FAO: Planning Department,  
Welwyn Hatfield Borough Council

Ref: 6/2021/3107/HOUSE  
Date: 04/02/2022

## HISTORIC BUILDINGS AND CONSERVATION ADVICE

### **RE: 2 Densley Close Welwyn Garden City AL8 7JX**

EXISTING CARPORT ELEVATIONS

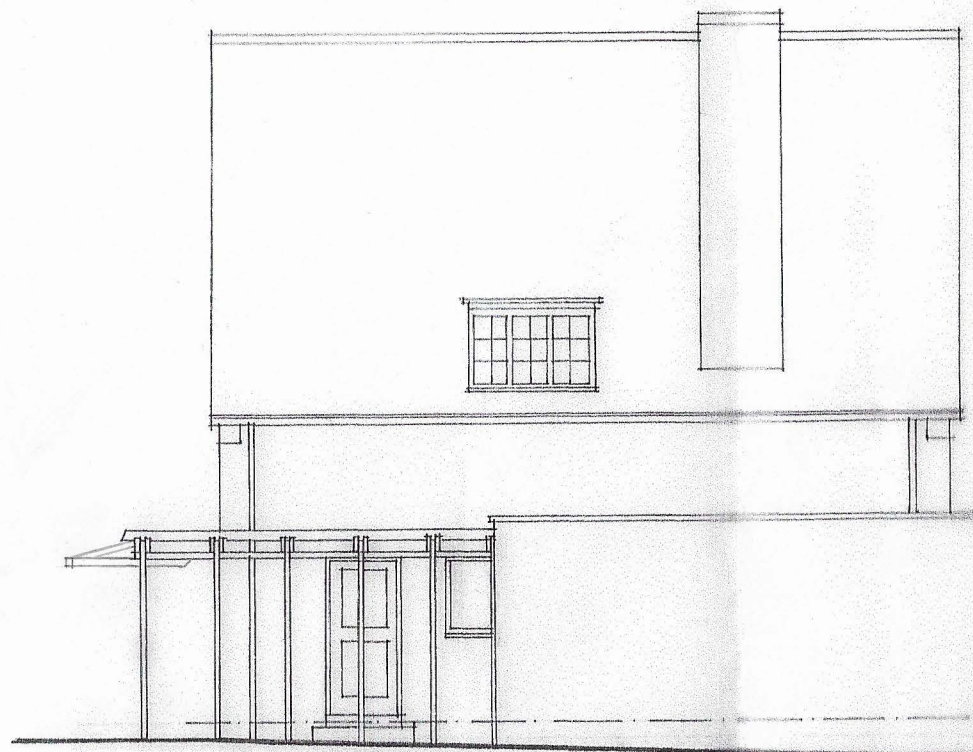
There are no objections to the demolition of the current carport which is a later alteration.

PROPOSED CARPORT ELEVATIONS

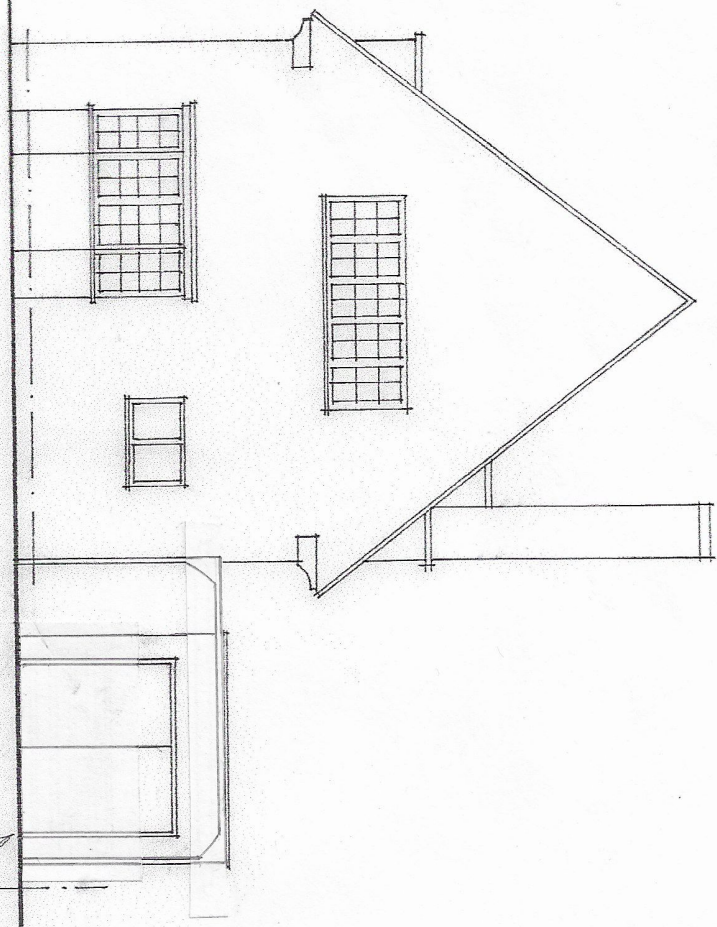
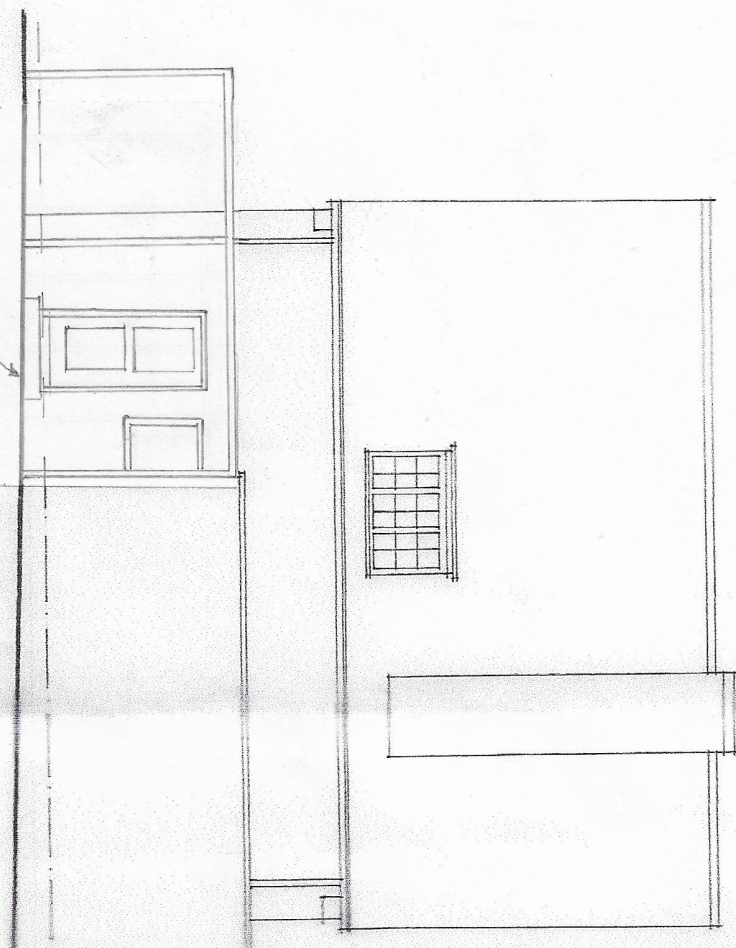
Not enough detail has been supplied regarding the changes to the carport, contrary to paragraph 194 of the NPPF. The drawings show a simple, flat roofed structure but the submitted 'Pro-Port Canopies' brochure contains photographs of mono-pitch and apex canopies, so it is not clear what is proposed. However, it is clear that a modern, aluminium and polycarbonate carport is not in keeping with the character and appearance of the conservation area, and therefore not appropriate. When discussing the Residential Area, The Welwyn Garden City Conservation Area Appraisal states that 'Small but unthinking alterations....can irreversibly degrade an otherwise interesting "original" house, or a whole group of houses' and this would be the case with the proposals as they currently stand. This is not to say that in principle a new carport or garage is not acceptable, only that any design would need to be in keeping with the character and appearance of the house and the conservation area, and would need to not project beyond the front elevation of the house

The proposals do not preserve or enhance the character or appearance of the Conservation Area, contrary to Section 72(1) of the Planning (Listed Buildings and Conservation Areas) Act 1990. The harm to the significance of the Conservation Area is 'less than substantial' and paragraph 202 of the NPPF is relevant.
